Application Ref:	3/2025/0323			 <div>Ribble Valley Borough Council</div> <div>www.ribblevalley.gov.uk</div>
Date Inspected:	02/06/25	Site Notice:	N/A	
Officer:	LW			
DELEGATED ITEM FILE REPORT:				APPROVAL

Development Description:	Proposed first floor infill extension to rear. Single storey extension to rear across the full width of the house.
Site Address/Location:	1 Northacre Drive, Barrow, BB7 9XT.

Drawing Title	
Extensions to Rear Existing & Proposed Plans & Elevations

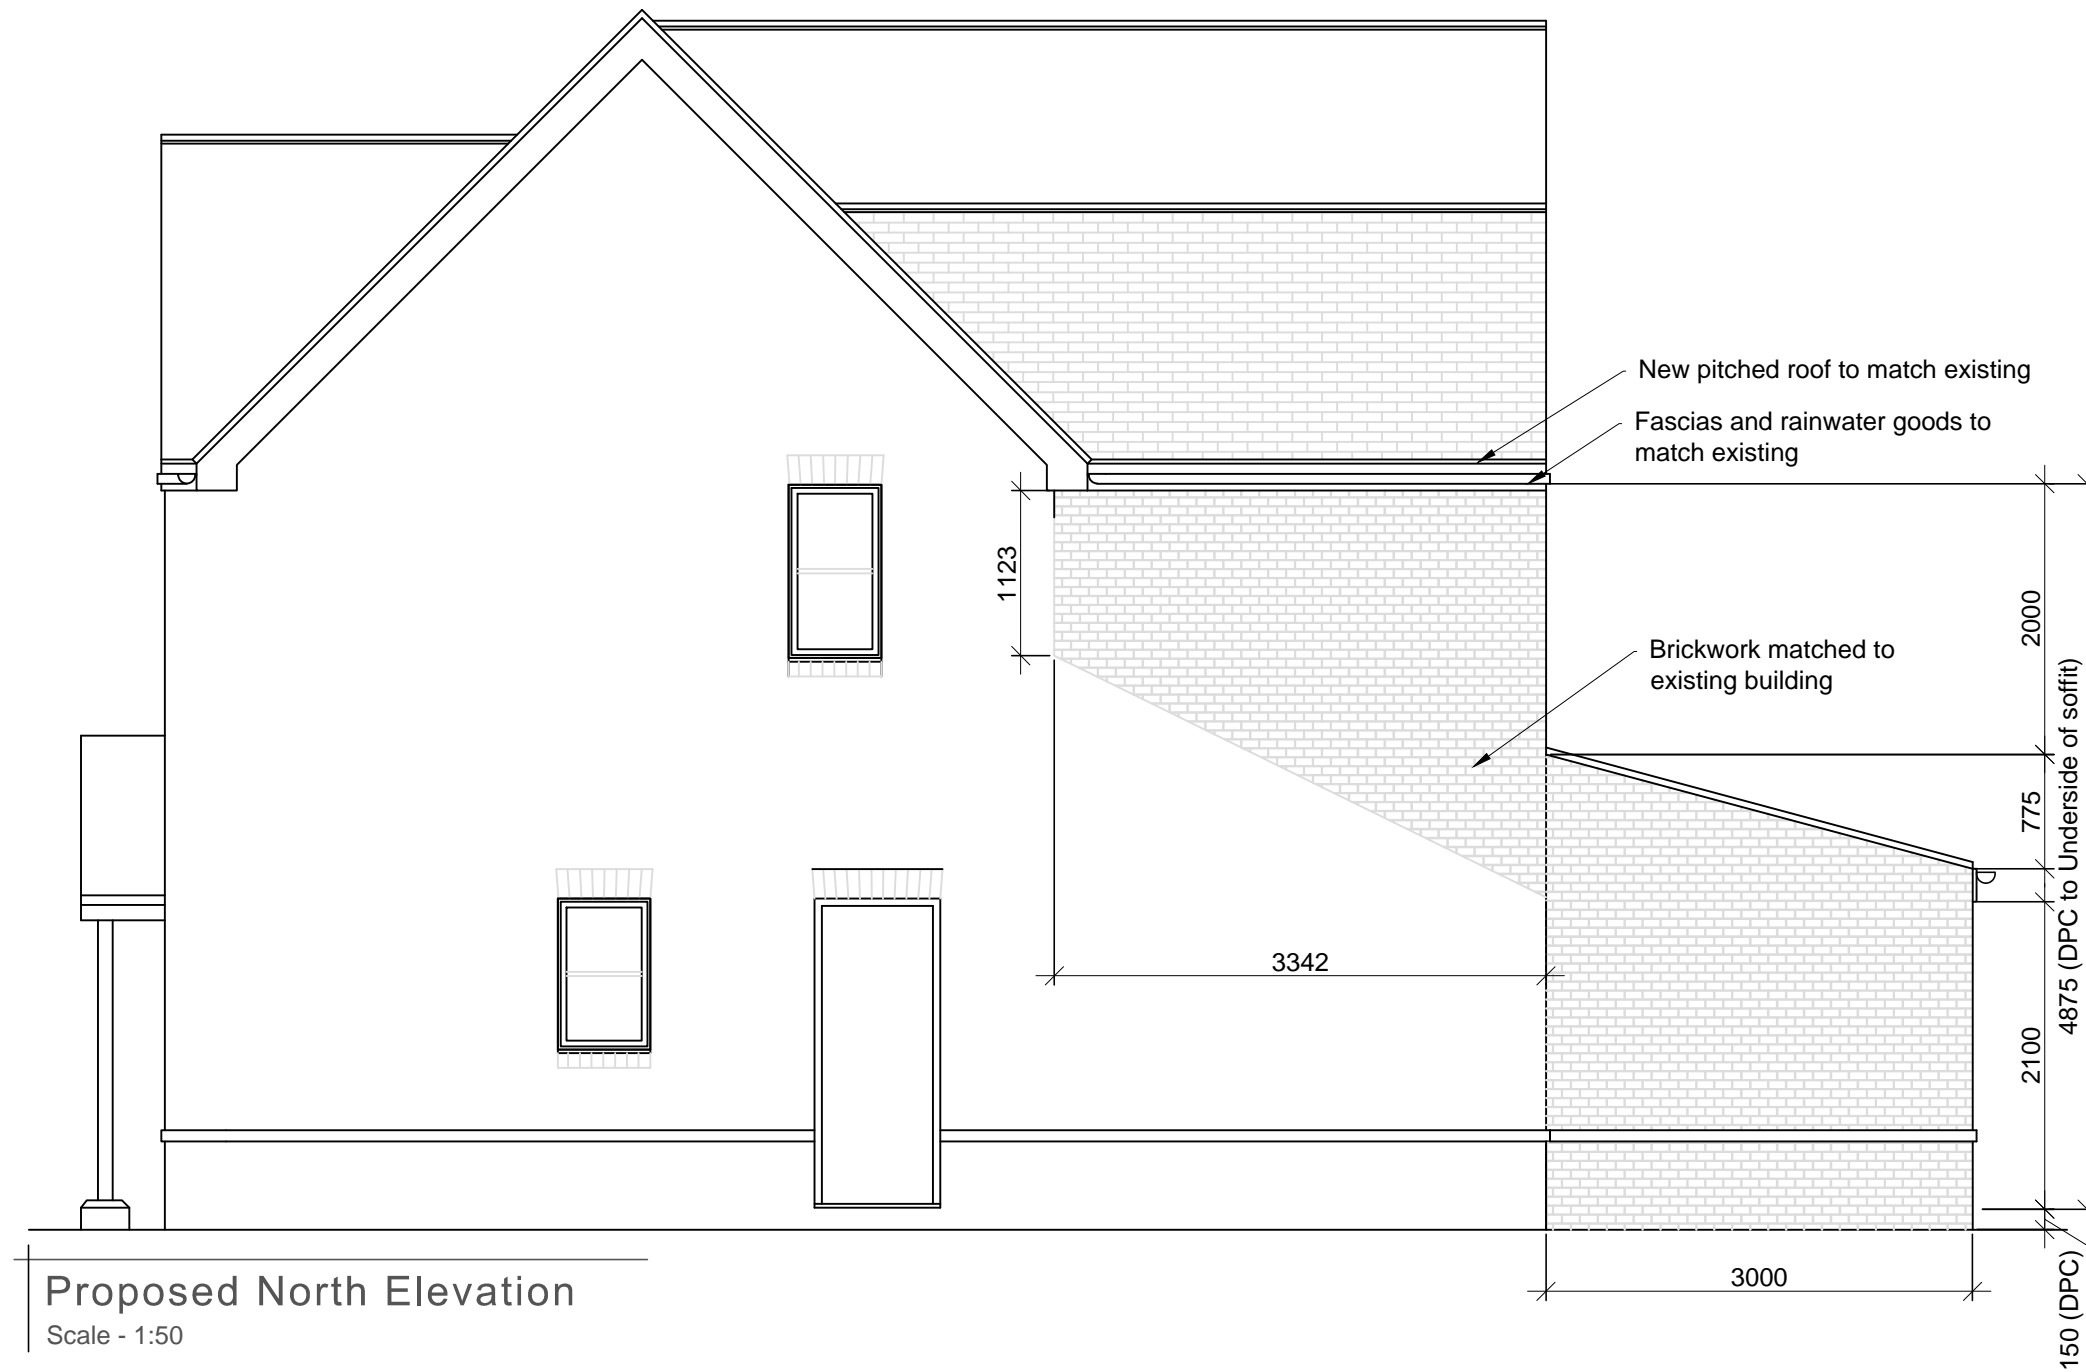
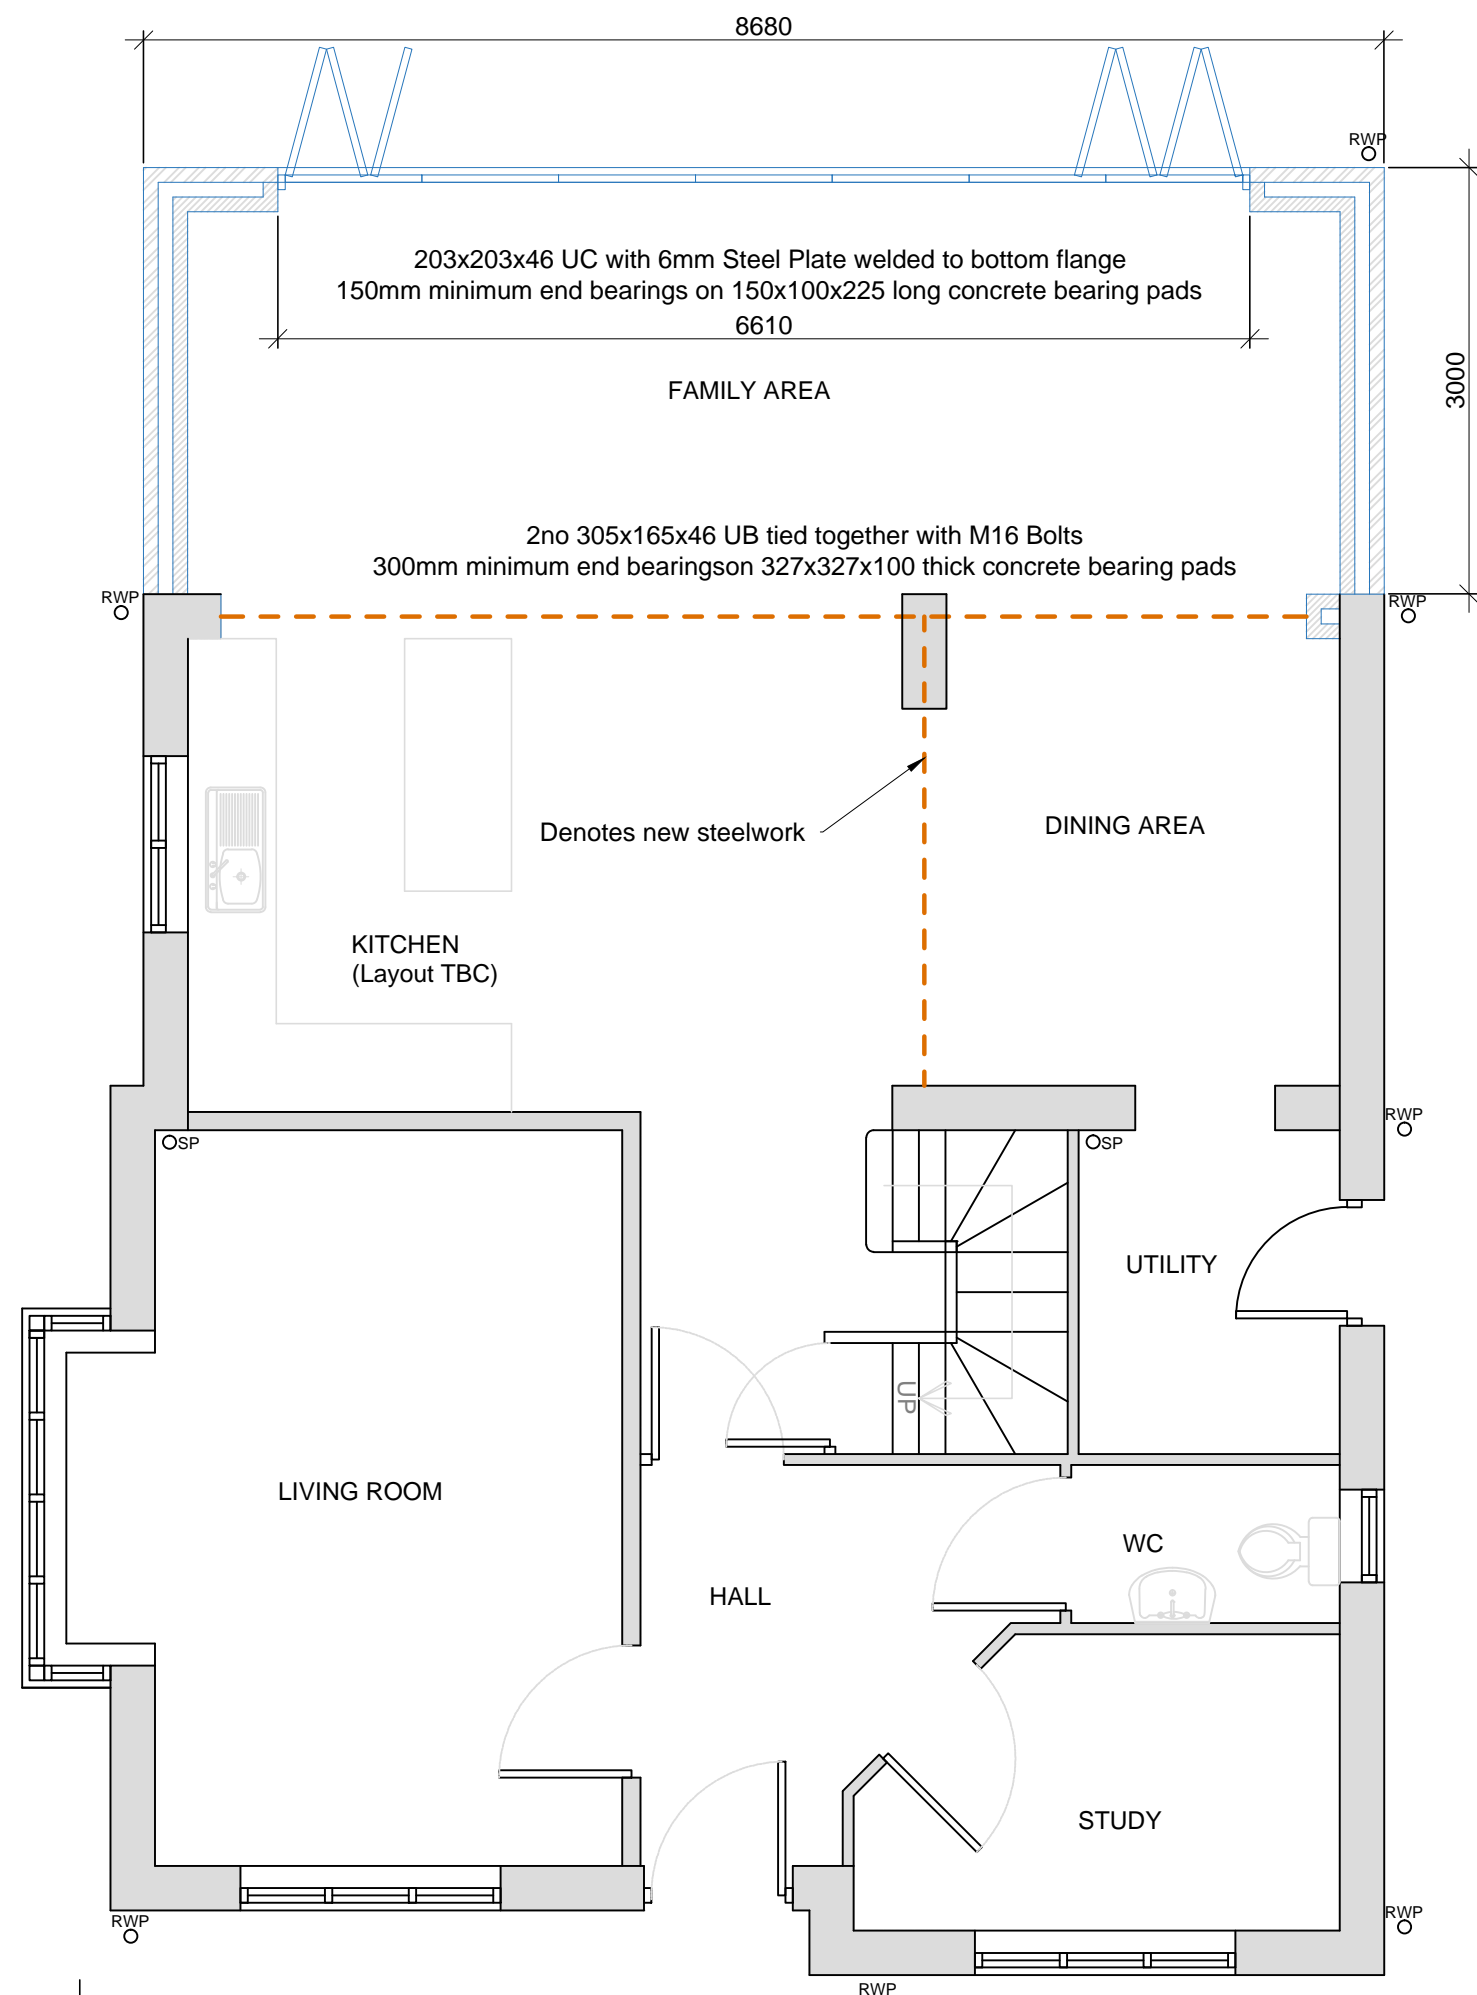
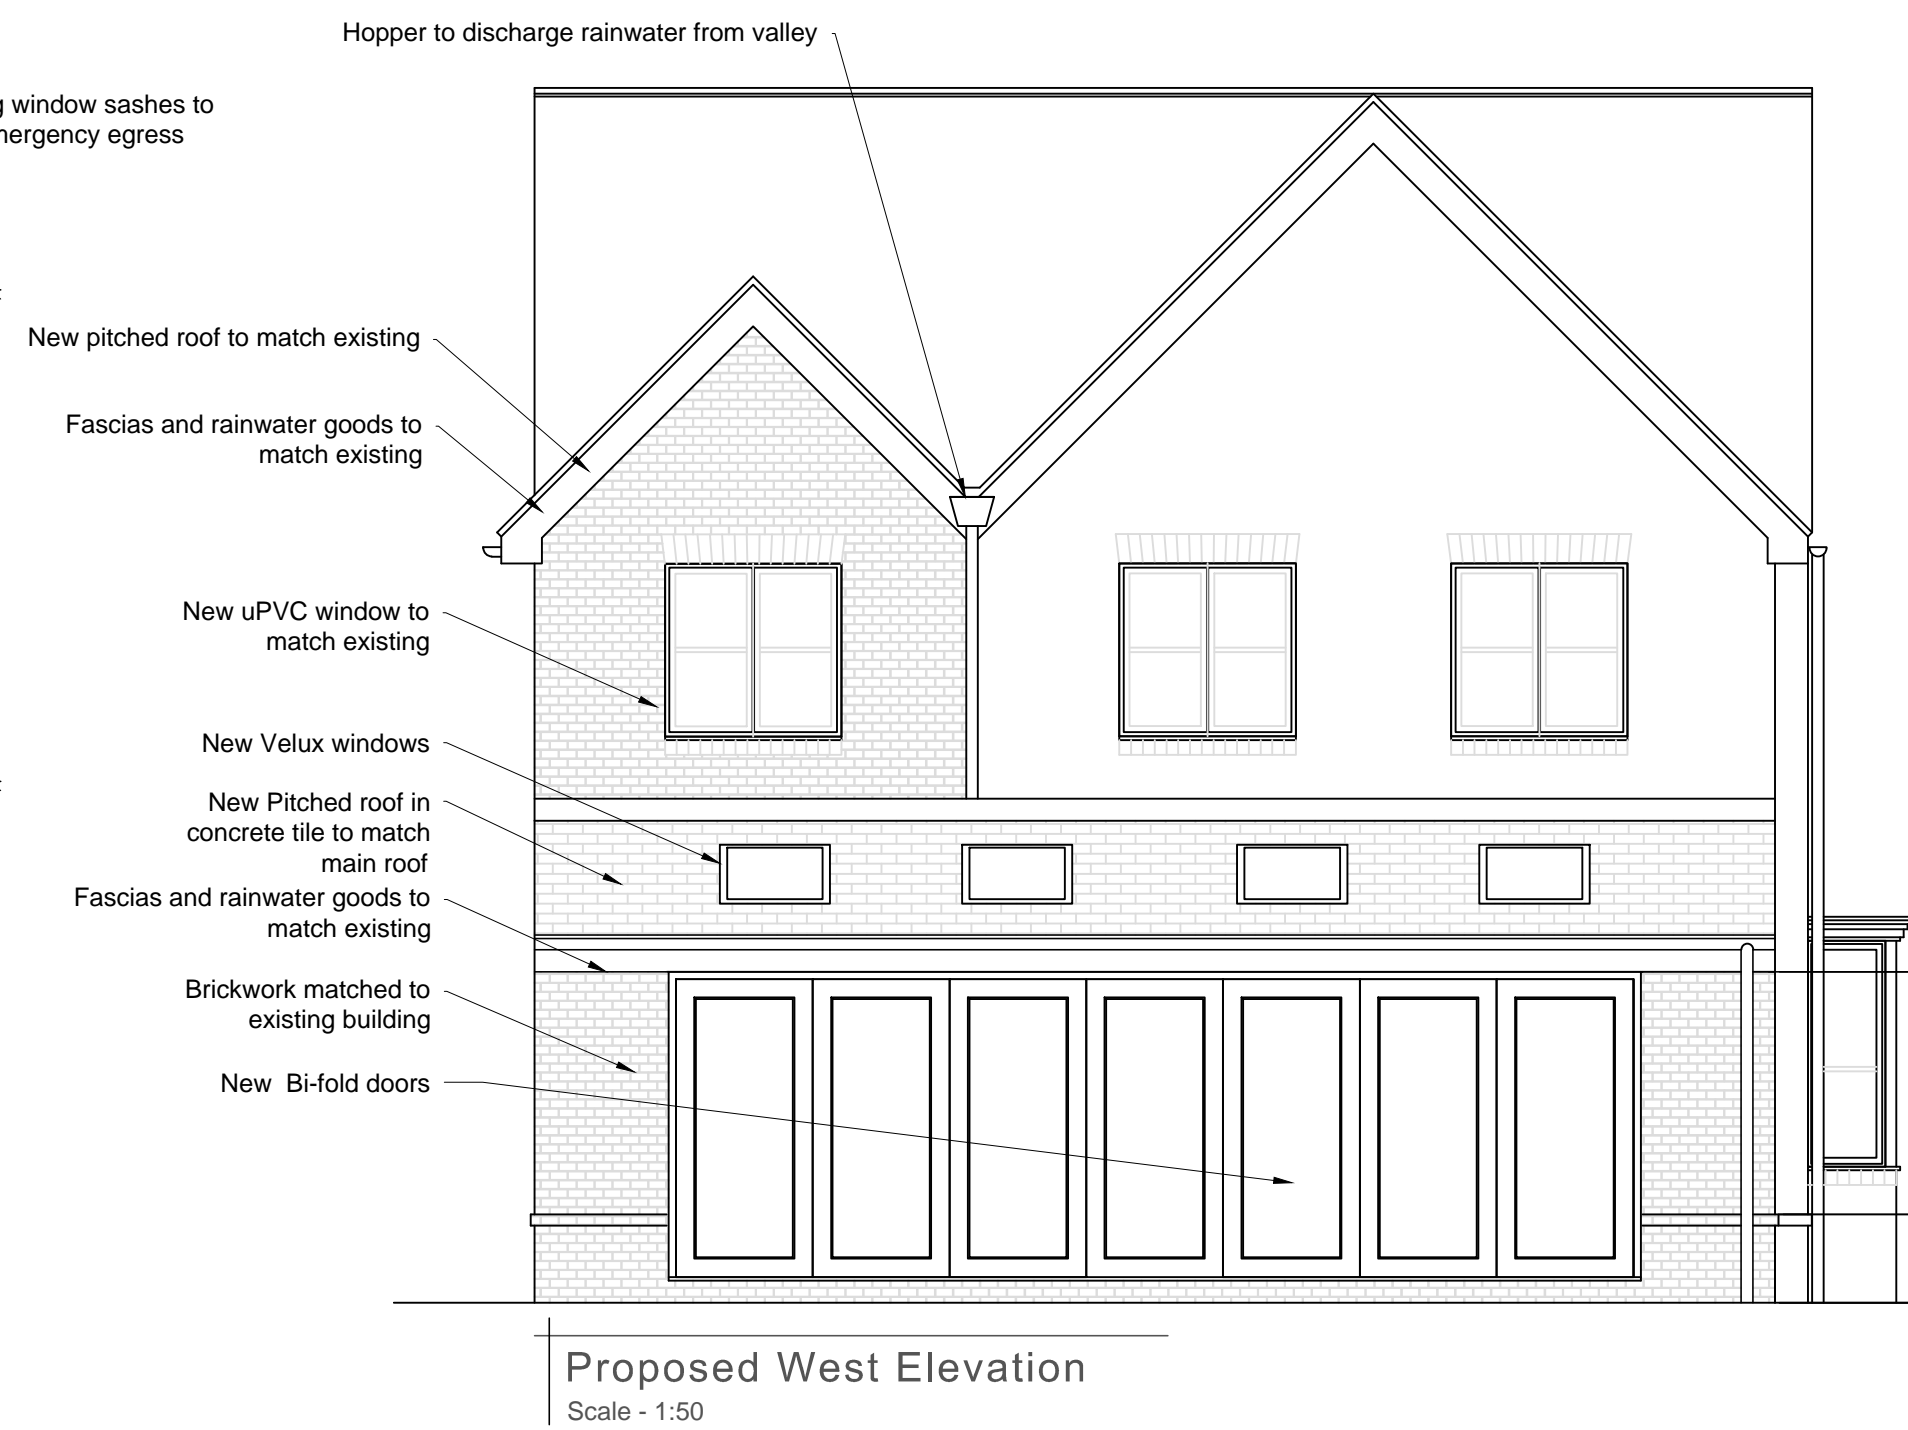
The proposed development as originally submitted was not considered to comply with the above. Whilst the size, scale, and materiality of the first-floor extension was deemed to be appropriate and in proportion with the existing dwellinghouse, the incorporation of a proposed flat roof form was considered to result in an unsympathetic and poorly designed form of development due its visual relationship with the existing pitched roof forms of the application dwelling.

In addition to the above, there were also concerns regarding the impact of blocking up of 2no. windows to the southern roadside frontage of the dwelling. Whilst it is acknowledged that this element of the original proposal may fall to be permitted development, as the proposed alterations had been submitted as part of the planning application, and shown on the submitted plans, then an assessment of the impact upon external appearance and visual amenity was required.

In this respect, although it is recognised that a number of nearby dwellings benefit from a single blocked up window at first floor, these are understood to have been included as part of the original design of a minority of house types within the housing development. Notwithstanding this, the proposed alterations at the application property included the blocking up of both the ground and first floor openings featured to the southern side elevation of the property, directly fronting Middle Lodge Road. The proposed alterations, if implemented, would therefore take a visually prominent position with the existing street scene, resulting in a large expanse of solid wall which would appear at odds with the solid-to-void ratio featured to the remainder of the application dwellinghouse.

In view of the above, it was determined that the originally proposed first floor extension, by virtue of its flat roof form, would result in an unsympathetic and poorly design from of development, which together with the blocking up of the 2no. windows to the southern elevation of the main dwellinghouse, would result in poor design, harmful to the visual amenities of the host property and surrounding area.

Following discussions with the applicant, a revised scheme has been submitted. The originally proposed flat roof form featured to the first-floor extension has been replaced by a reverse gable design, while the 2no. windows to the side elevation of the primary dwellinghouse are shown to be retained. On balance, these measures are considered sufficient to address the aforementioned concerns.
